**STATEMENT OF ENVIRONMENTAL EFFECTS: SECTION 75W APPLICATION TO MAJOR
PROJECT MP NO.08_0257 STAGE 1 (BUILDINGS 4 & 5) – 61 MOBBS LANE, EPPING**

Pursuant to Section 75W (1) (a) of the Environmental Planning and Assessment Act 1979, a 'modification of approval' is sought to vary Condition No. A2 pertaining to Major Project MP No. 08_0257 Stage 1 (Buildings 4 & 5) as approved on the 15 September 2010. The modification is to amend architectural plans to accommodate minor design changes to the approved architectural plans arising from design and construction compliance.

Title Building 4 East Elevation 1" = 2' 4" 1:100 @ A0										APPROVED: SP	A4201 SECTION 75W ISSUE REVISION B

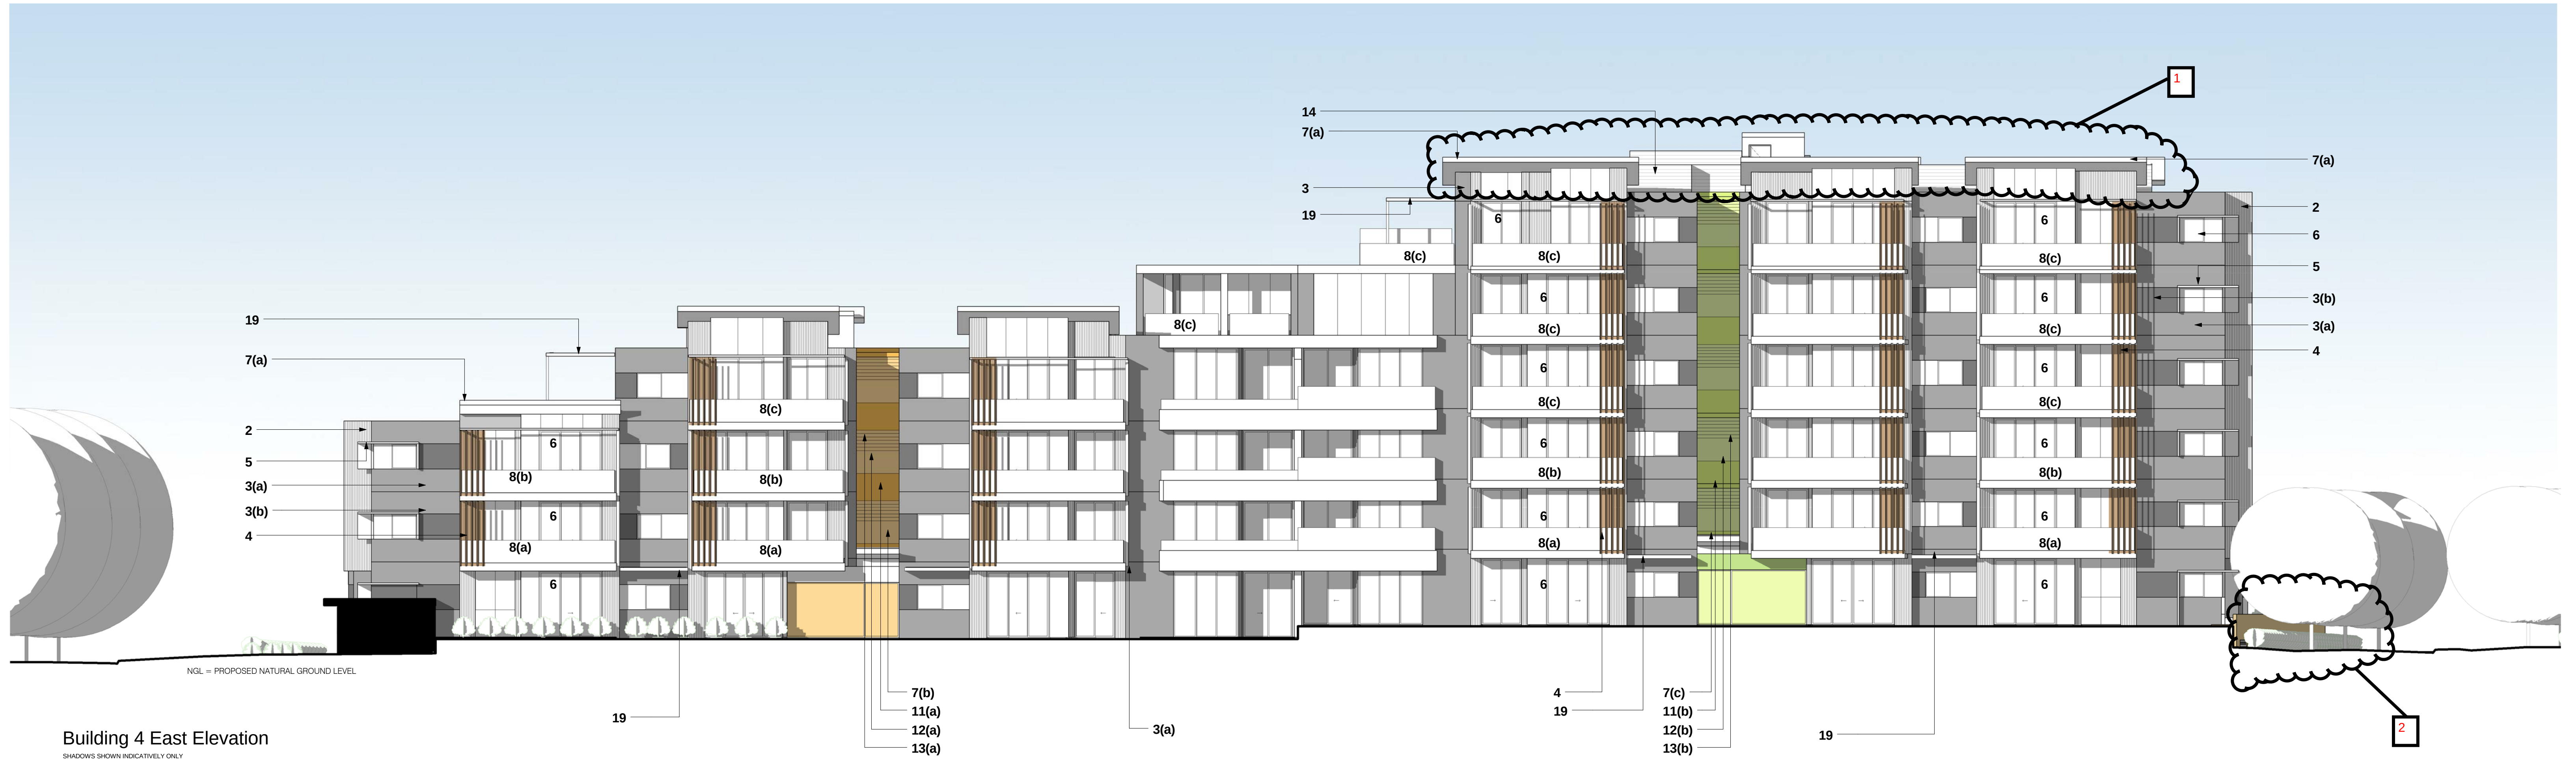
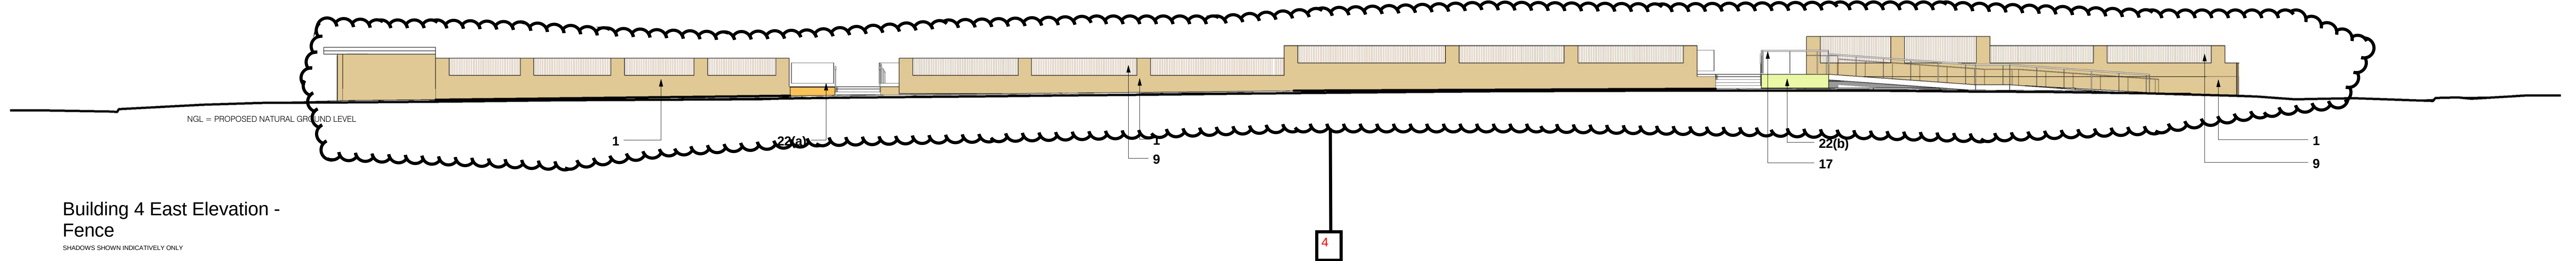
1. Roof details amended
2. Garbage room details updated/ driveway
3. Change fencing from timber to aluminium
4. Insert elevation of proposed fencing.

Epping Park
61 Morris Lane, Epping
Stage 1 (Building 4+5)
A5102
SECTION 75W ISSUE

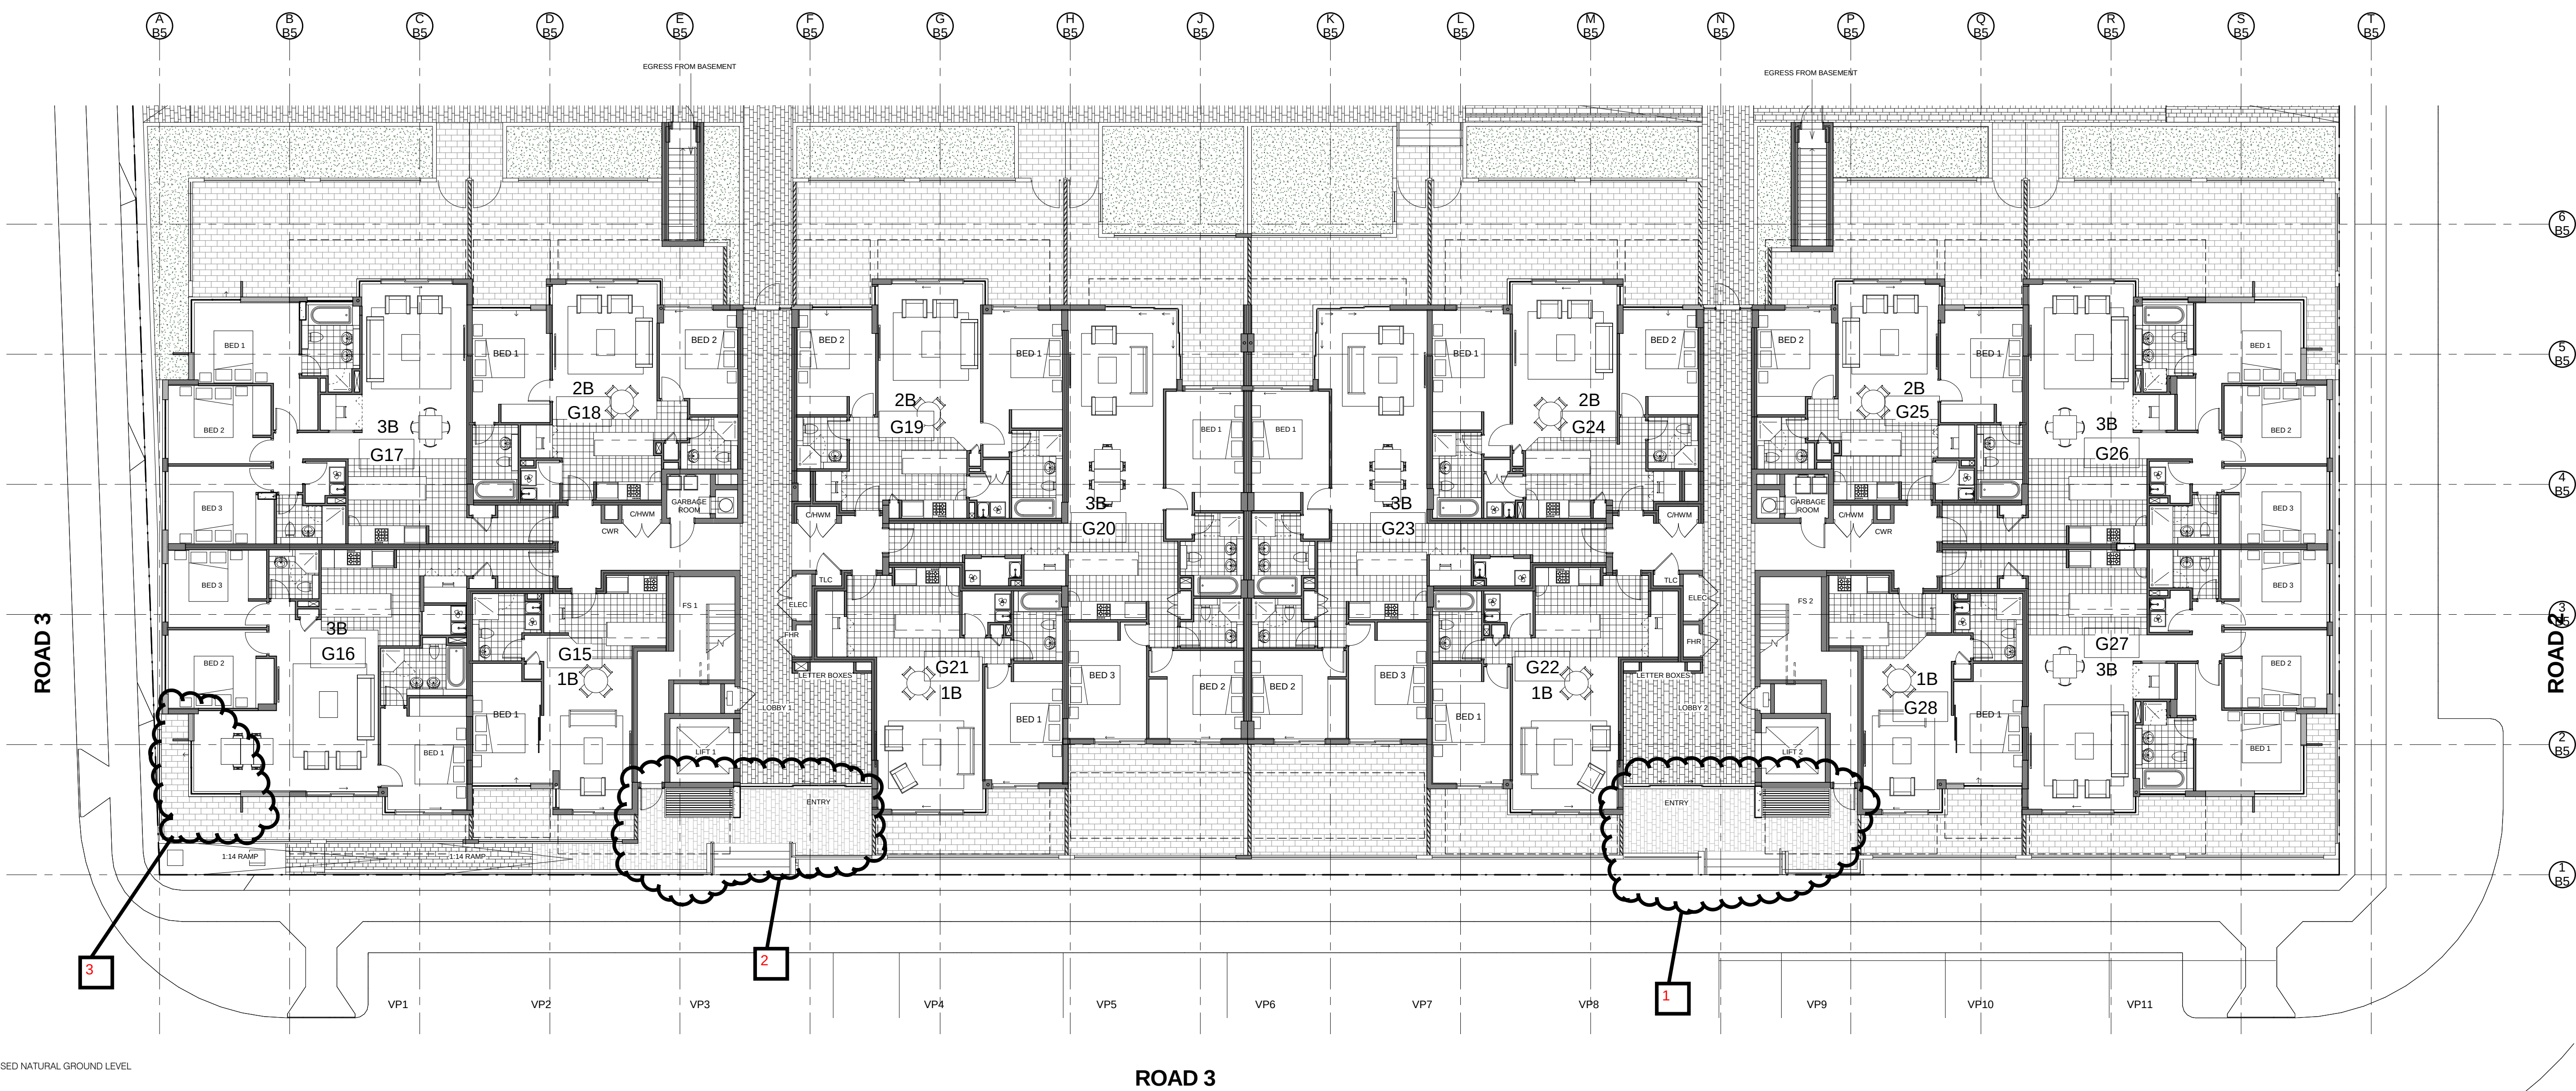
1. Reconfigure entry, stairs, landscape area and add air intake shaft
2. Reconfigure entry, stairs, landscape area and add air intake shaft
3. Reduce size of window awning

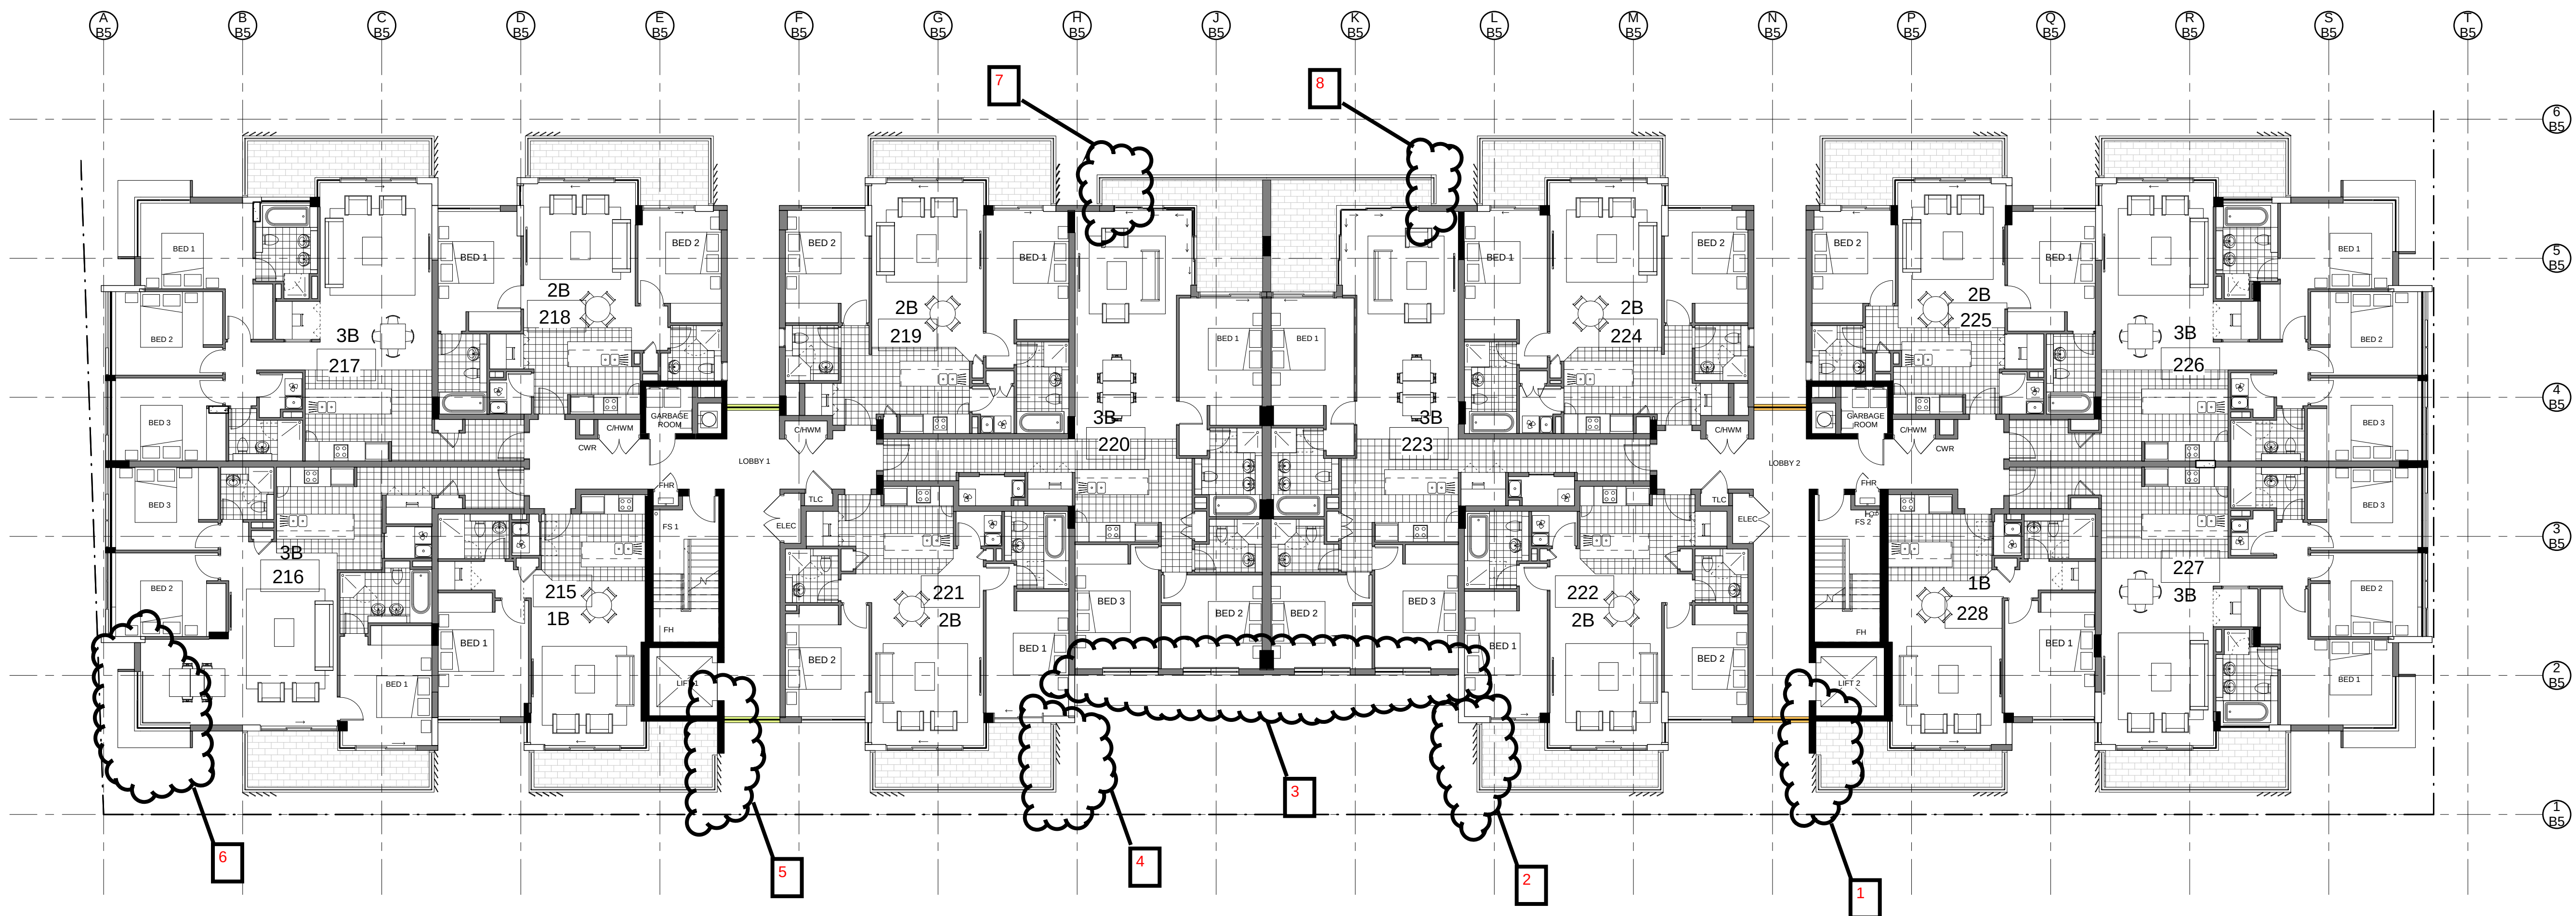
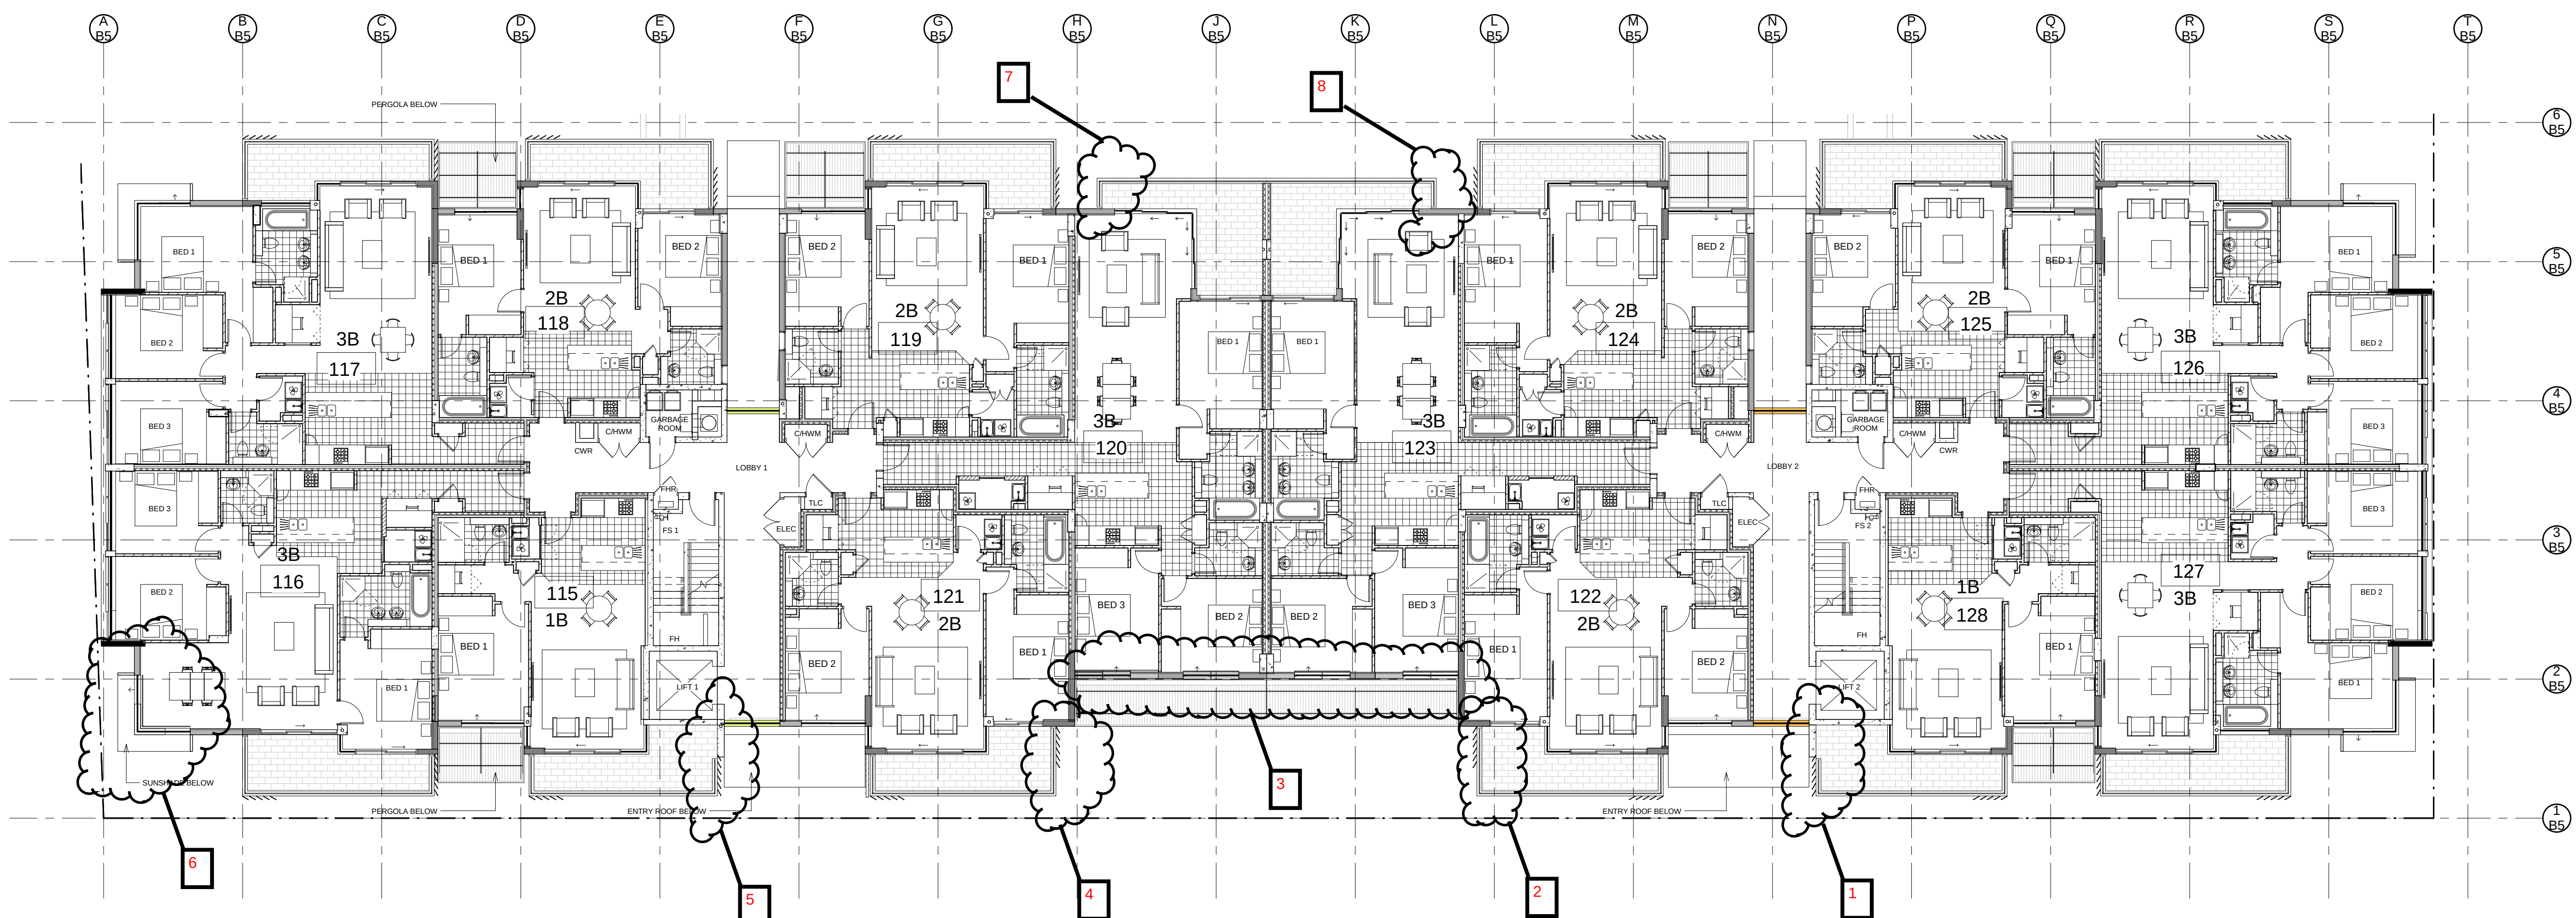
1. New louvre and concrete configuration
2. New louvre and concrete configuration
3. Amend precast panel and window configuration
4. New louvre and concrete configuration
5. New louvre and concrete configuration
6. Reduce size of window and awning
7. Delete louvre
8. Delete louvre

1. New louvre and concrete configuration
2. New louvre and concrete configuration
3. Amend precast panel and window configuration
4. New louvre and concrete configuration
5. New louvre and concrete configuration
6. Reduce size of window and awning
7. Delete louvre
8. Delete louvre
9. Precast panel and window reconfiguration
10. Parapet added
11. Parapet added
12. Precast panel and window reconfiguration
